Application No: EP/47/21/HH
Site Address: West House South Strand East Preston BN16 1PN
Description of works: Erection of second floor addition, part single storey side, part two storey front, side and rear extensions and alterations to fenestration/openings

OWQC36496

This council's Planning & Licensing Committee has considered this Application electronically.

**PROPOSED WEST ELEVATION.**

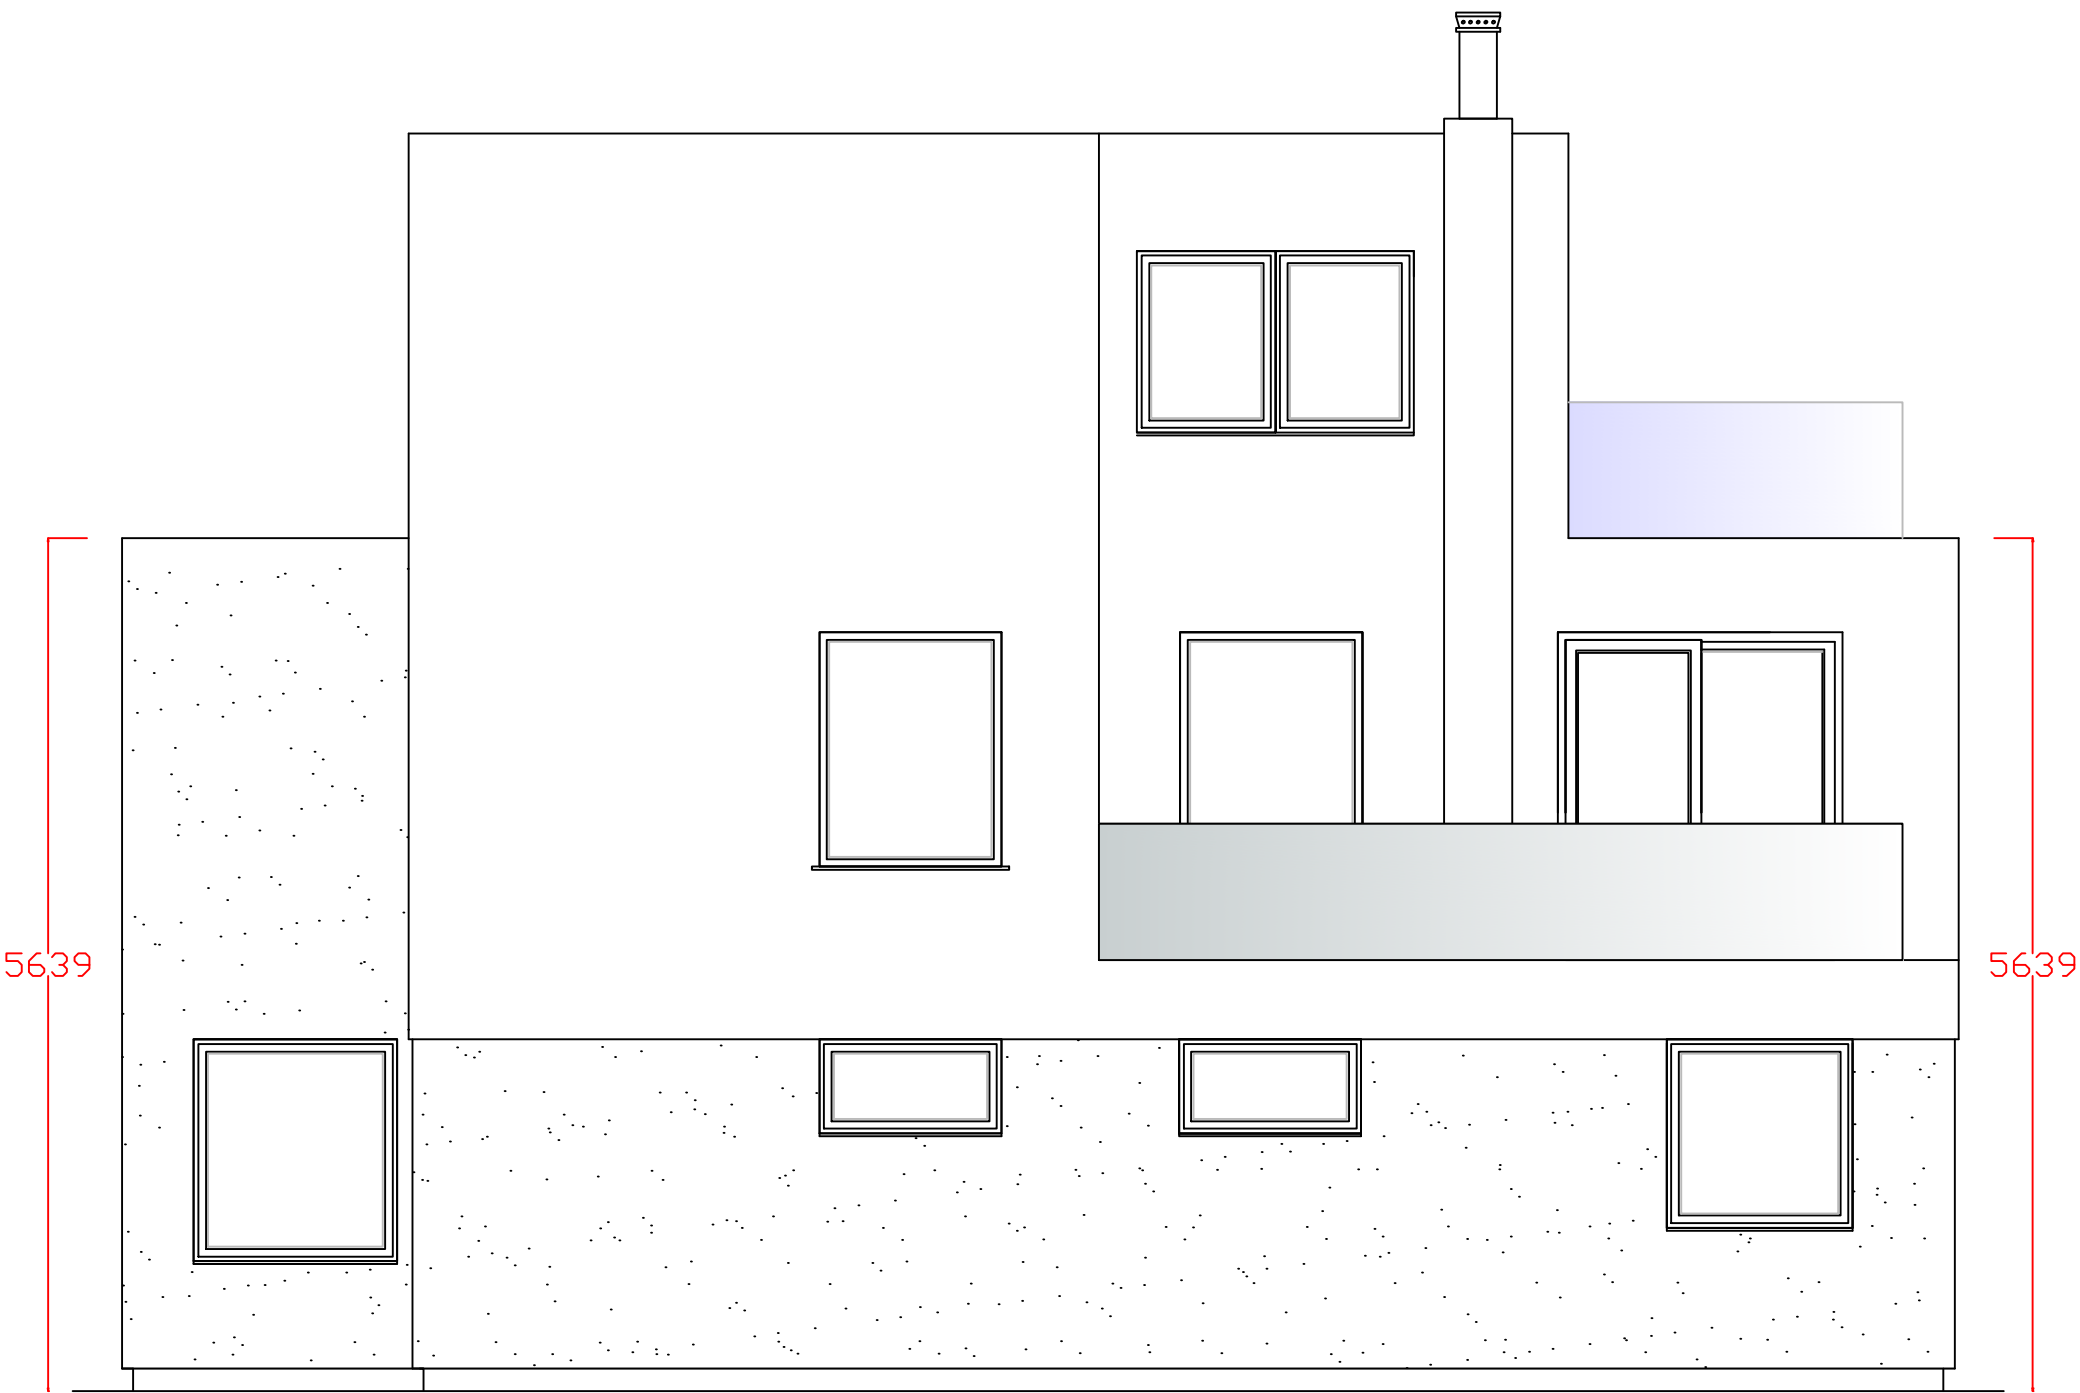
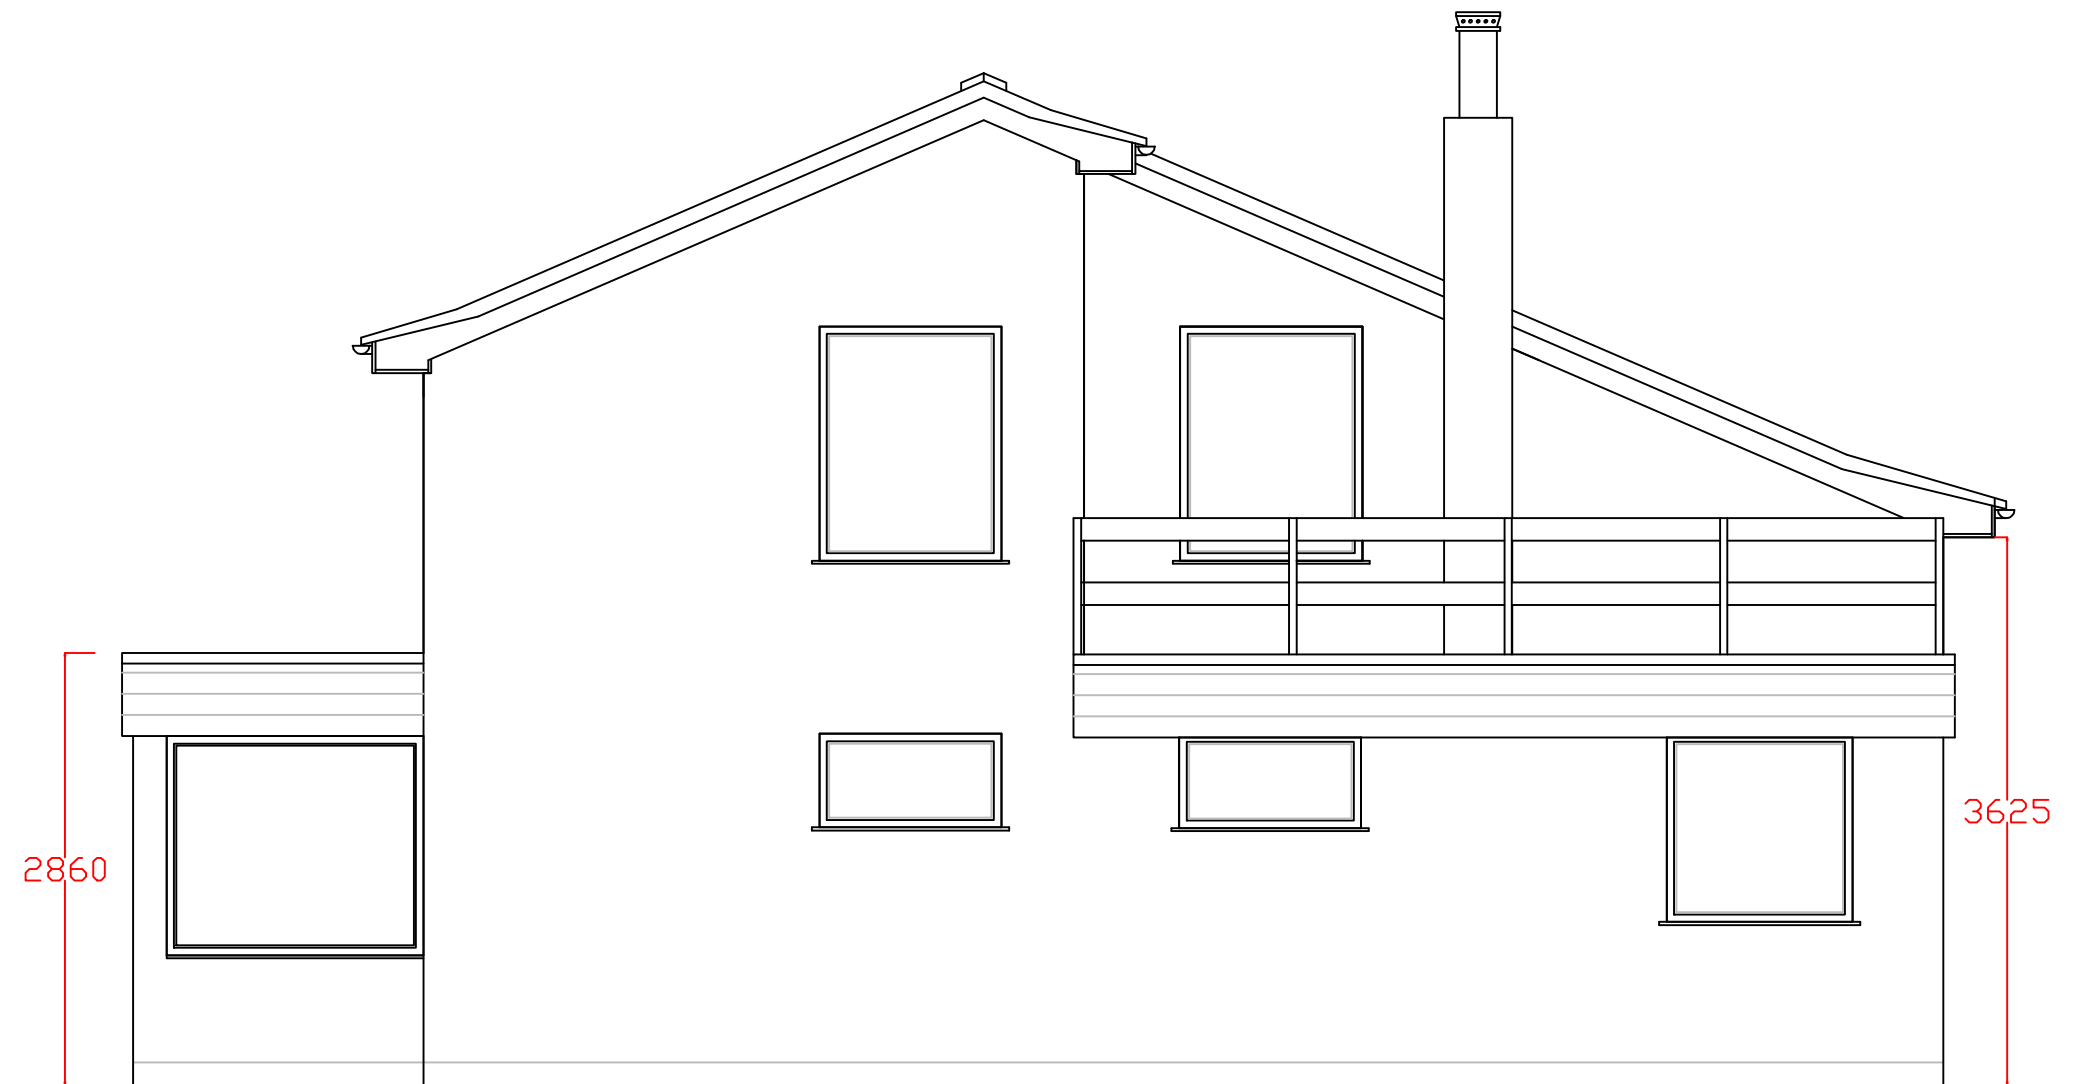
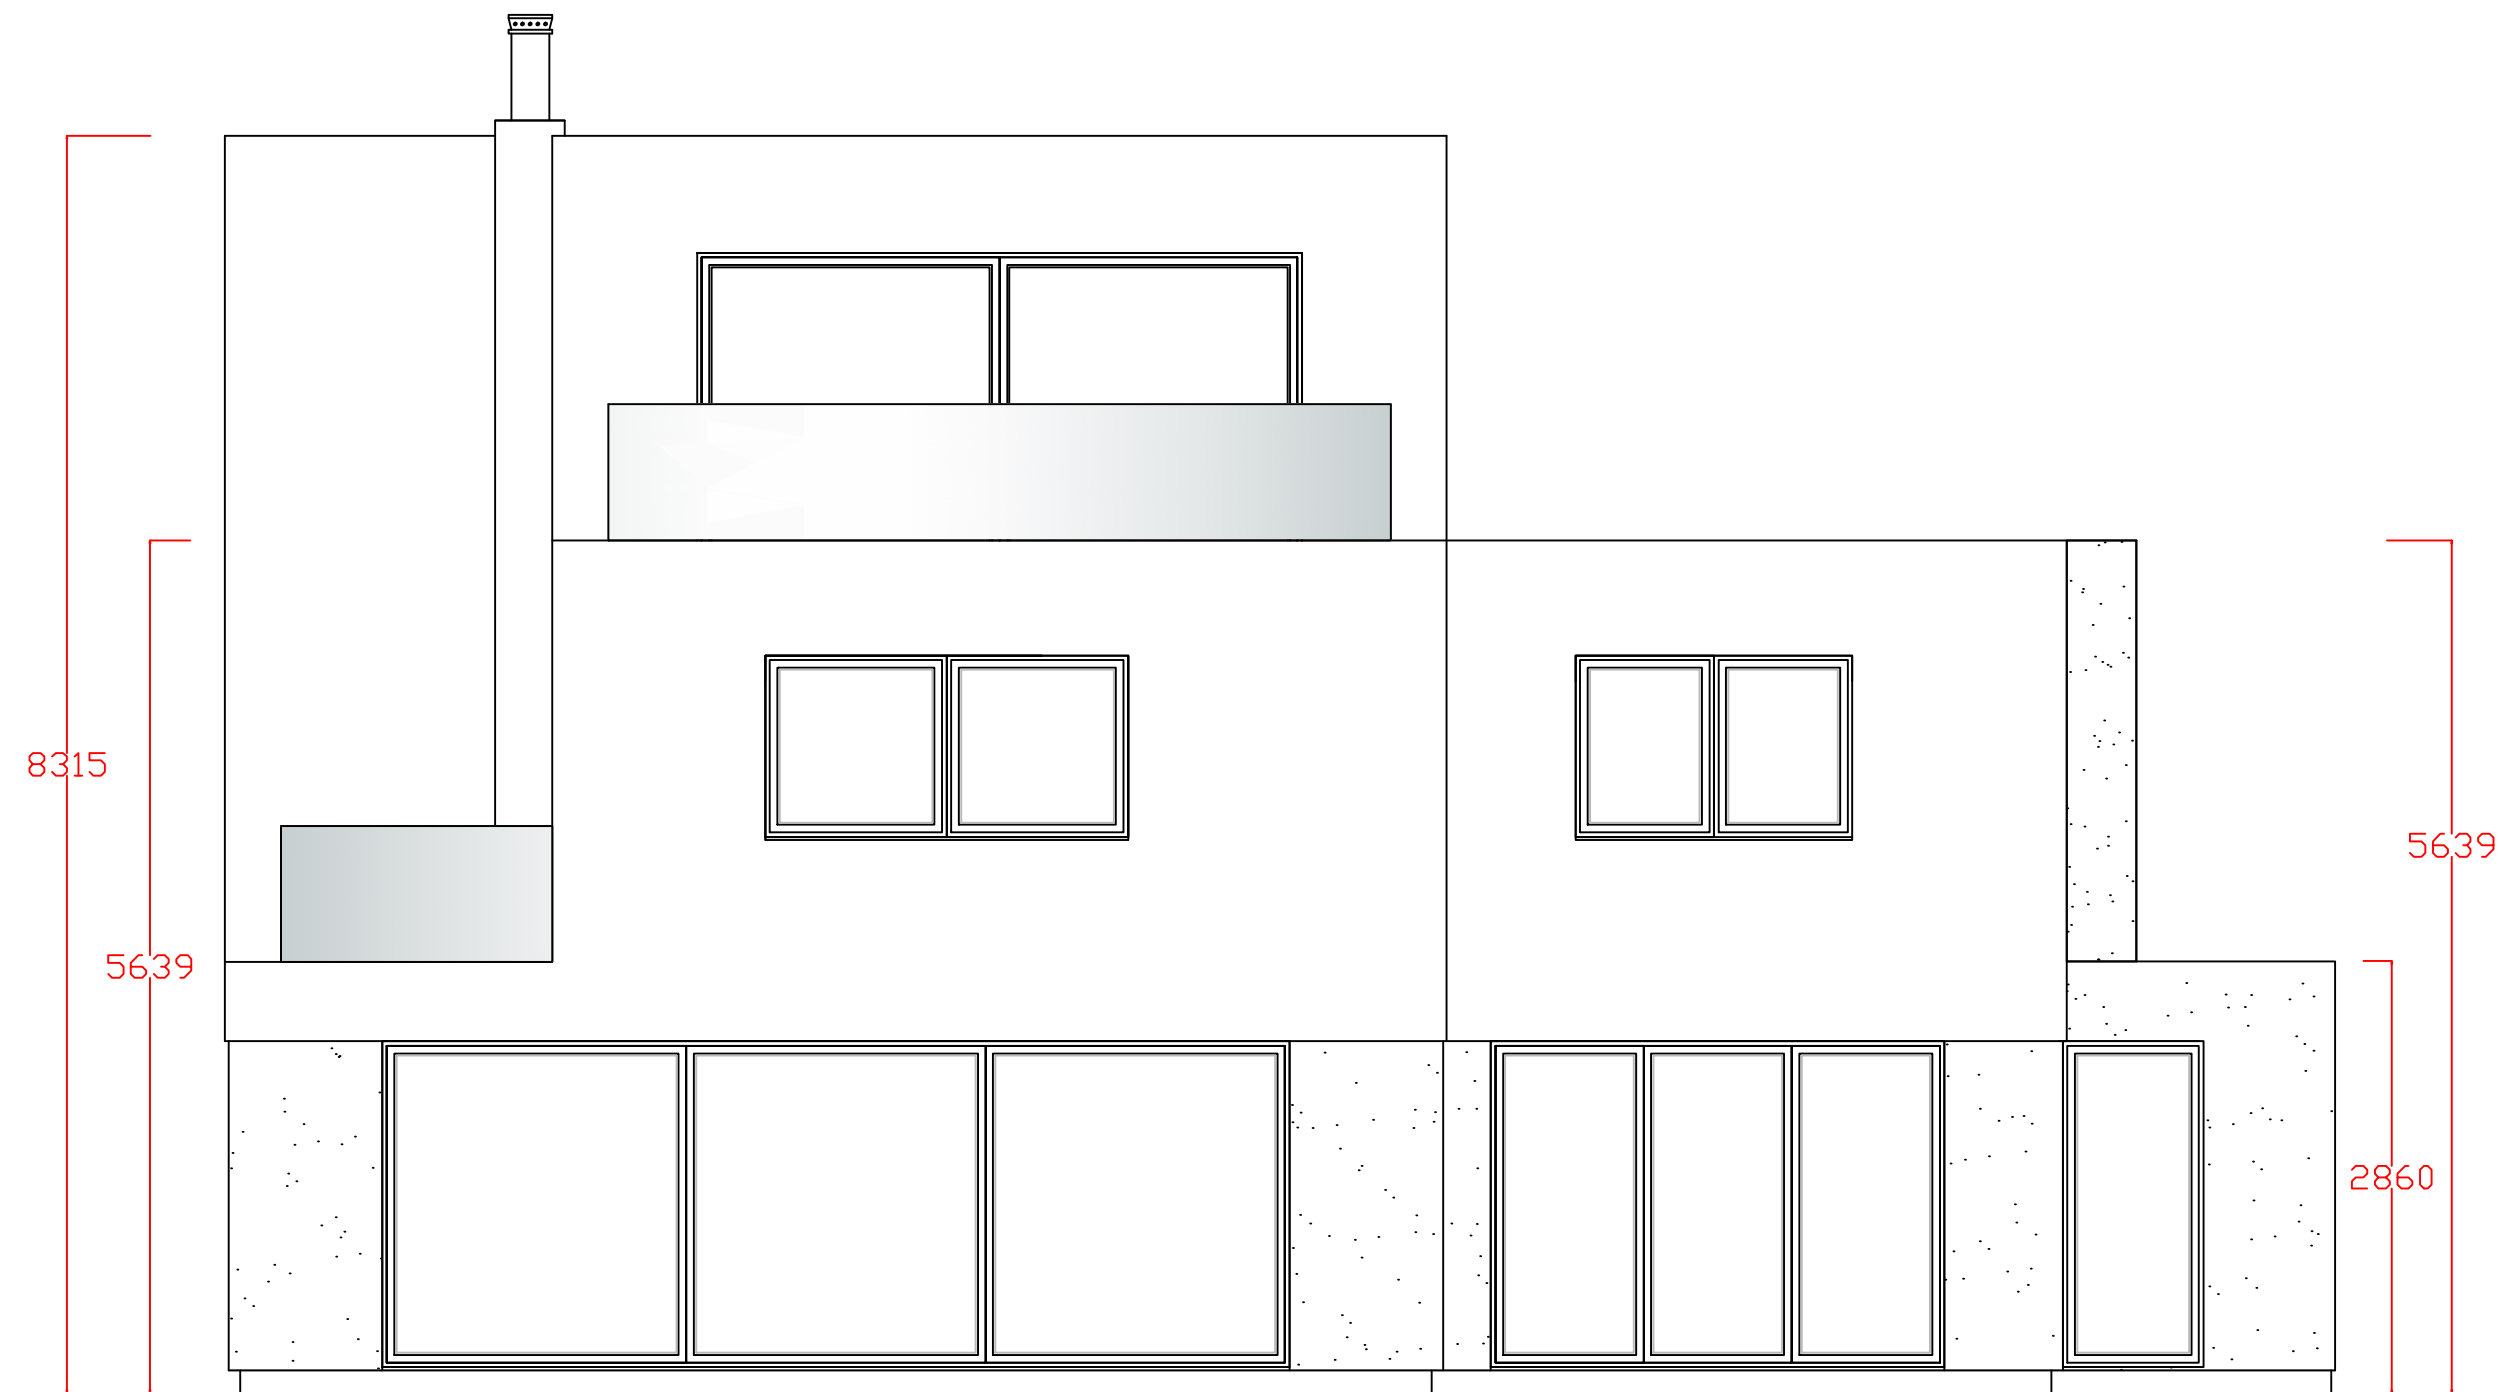
The proposed materials do not harmonise in both colour and texture with the materials used in adjoining buildings thus conflicting with Policy 1 of the Neighbourhood Plan. This council does not believe Rockpanel cladding of the sort described in the application form is not visible on any building in the vicinity of West House.
